City of Albuquerque Stormwater Construction Site Inspection Report

ESC File No.	M21E018_R	Project Name:	Raylee Homes at Juan Tabo Hills Estates		
NPDES Id. No.	NMR1002FM	Location:	Popejoy, Rodey, and Sunset		
8/19/2022	Owner	Deligated Authority			
Operator	SLG Holdings, and TJT Group, LTD.	Raylee Homes field super			
Contact name & title	Jeff Grady	Sal Chavez			
e-mail	jgrady@rayleehomes.com				
Contact Phone #	505-975-7544	975-1505			
COA Inspector	James Hughes	Start/End Time:	1:30pm		
Construction Phase:	Vertical				
Type of Inspection:	Regular	Storm Event	Past Storm Event >0.25"	311/Complaint	Follow Up
Weather at time of inspection?		Cloudy	Temperature: ~		80
Estimated date of last storm 0.25" or greater		8/21/2022

Drawing file: M21E018_R / Raylee Volterra - BMP Map COPY.pdf

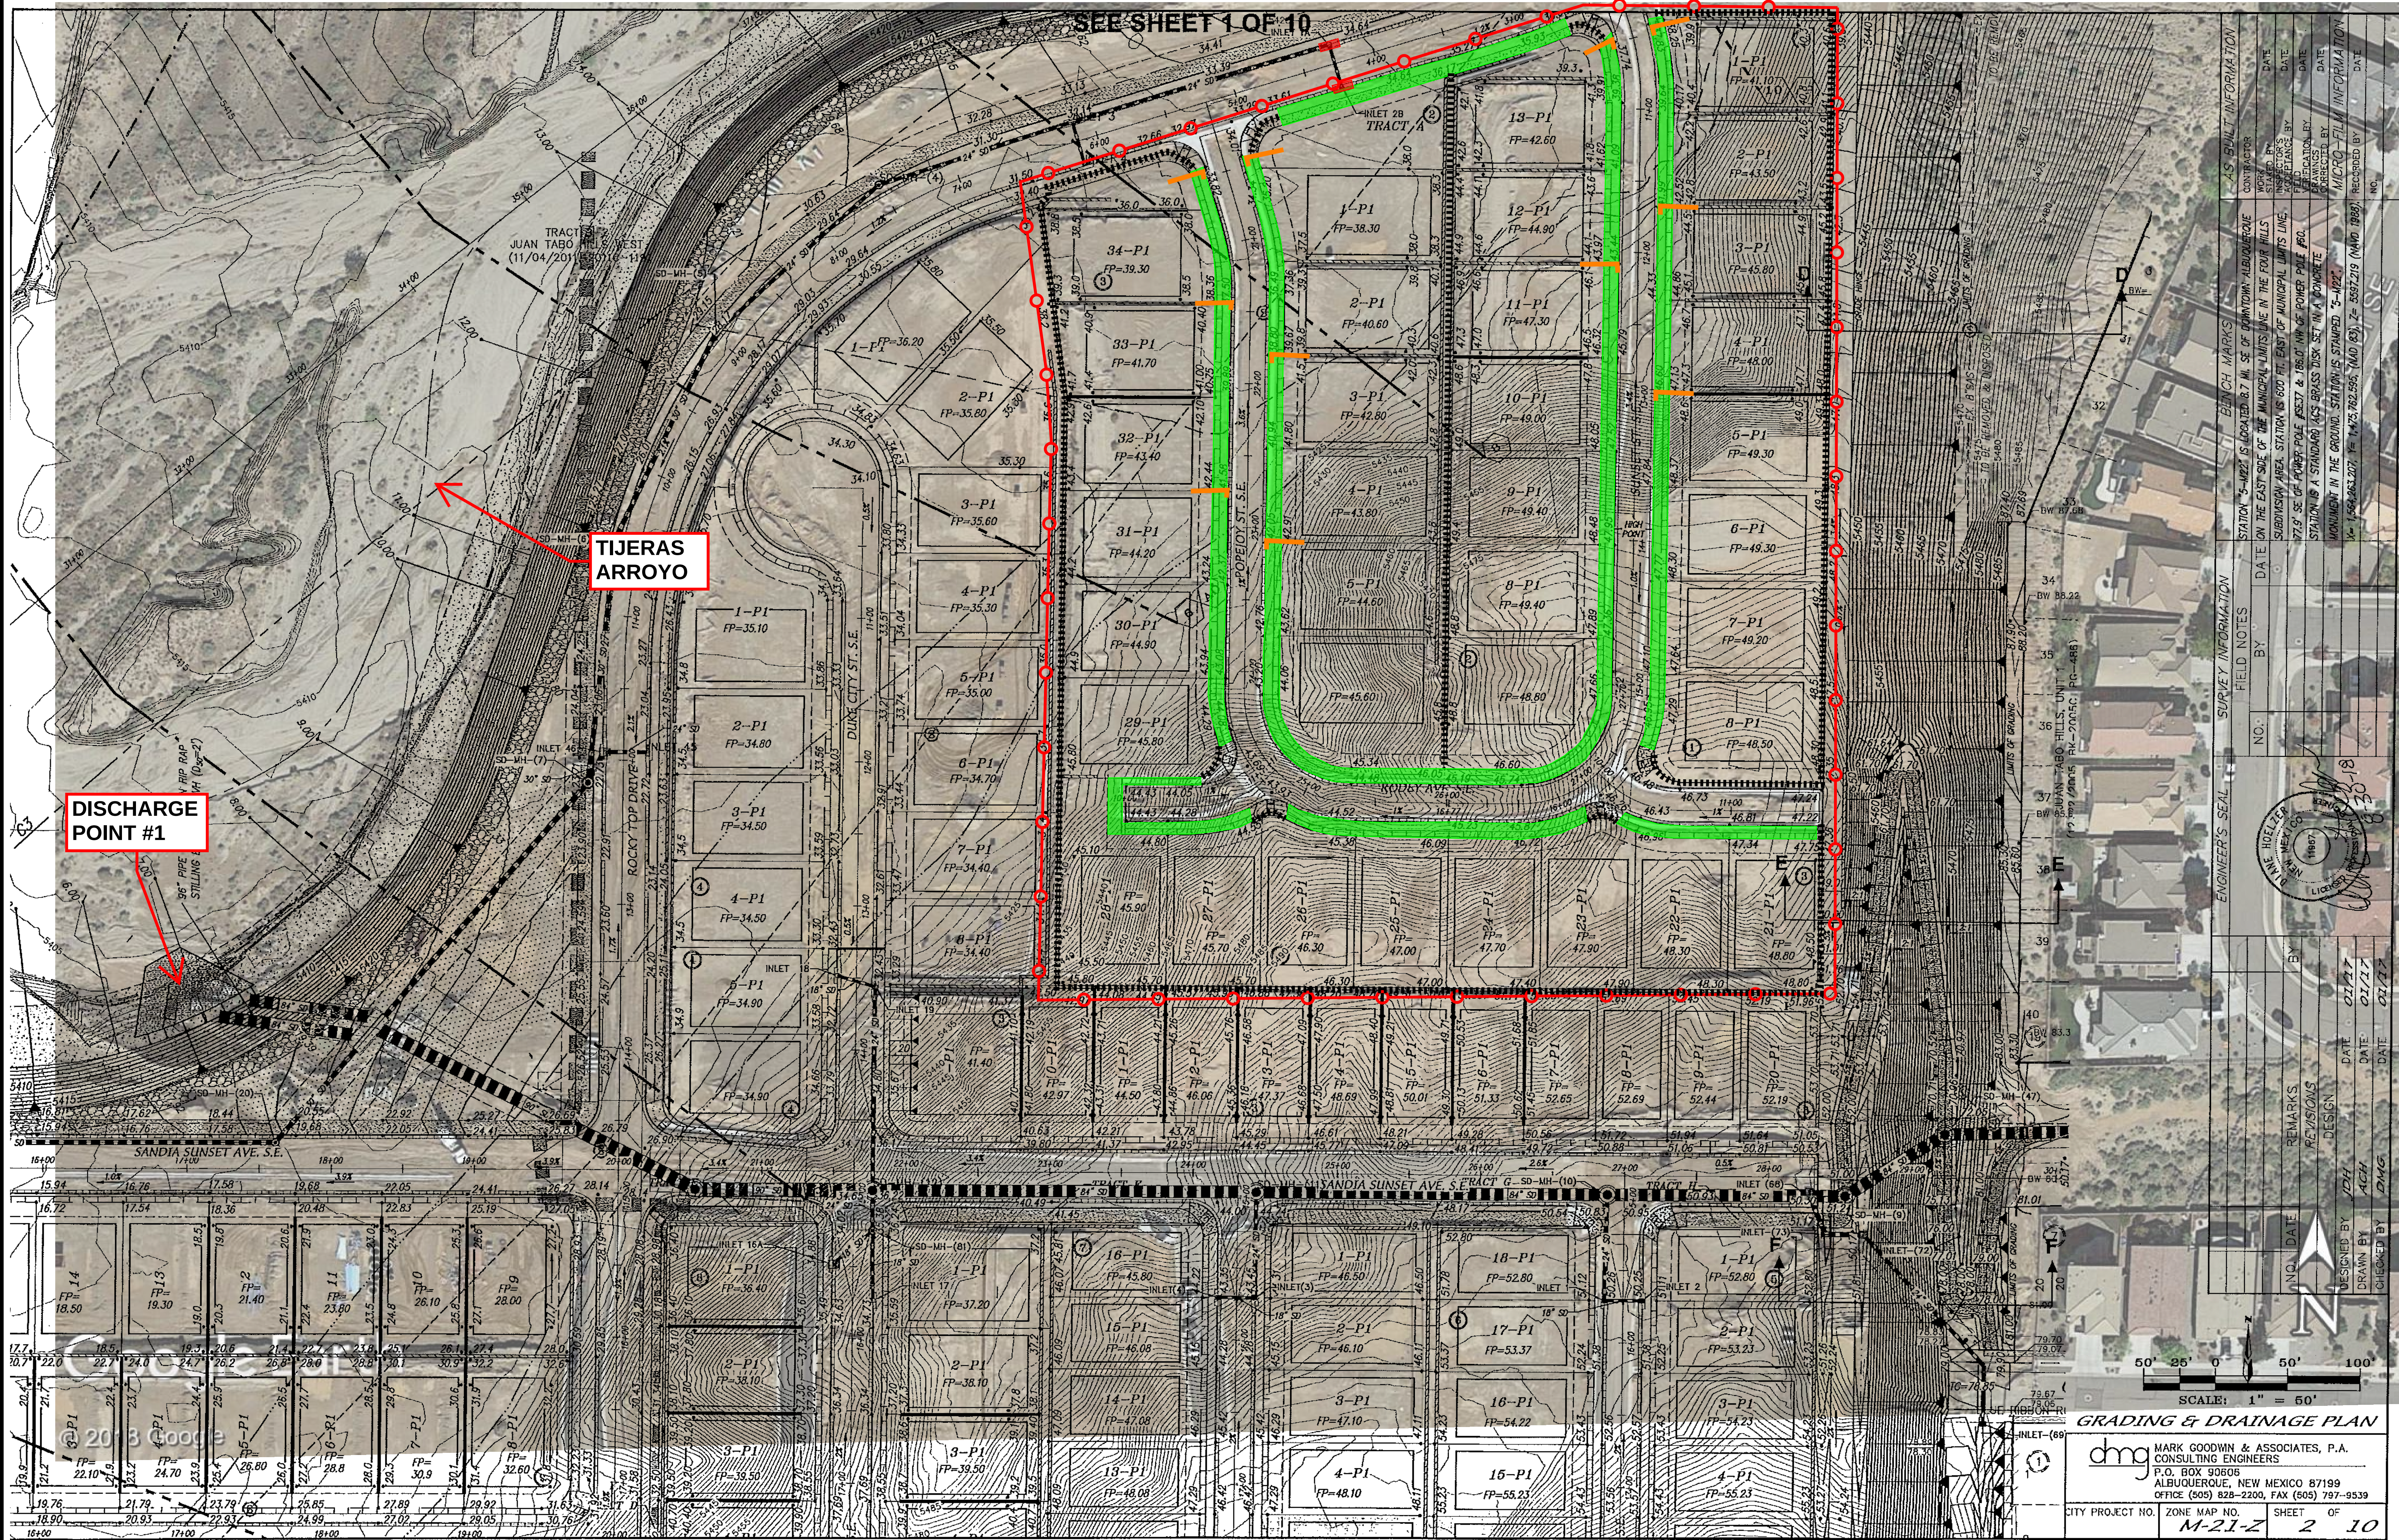
Item Number	Deficiency/ Corrective Action				
1	Remove inlet protection from all inlets downstream of the site in Rocky Top and clean sediment from streets and sidewalks. Keep sediment out of street!				
2	The cutback swale isn't enough. Keep the sediment out of the street by adding silt fence at low corner of each lot 15' x 15'.				
3	Minor washout on nw lot at SWPPP sign. Clean up and add washout containers.				
4					
5
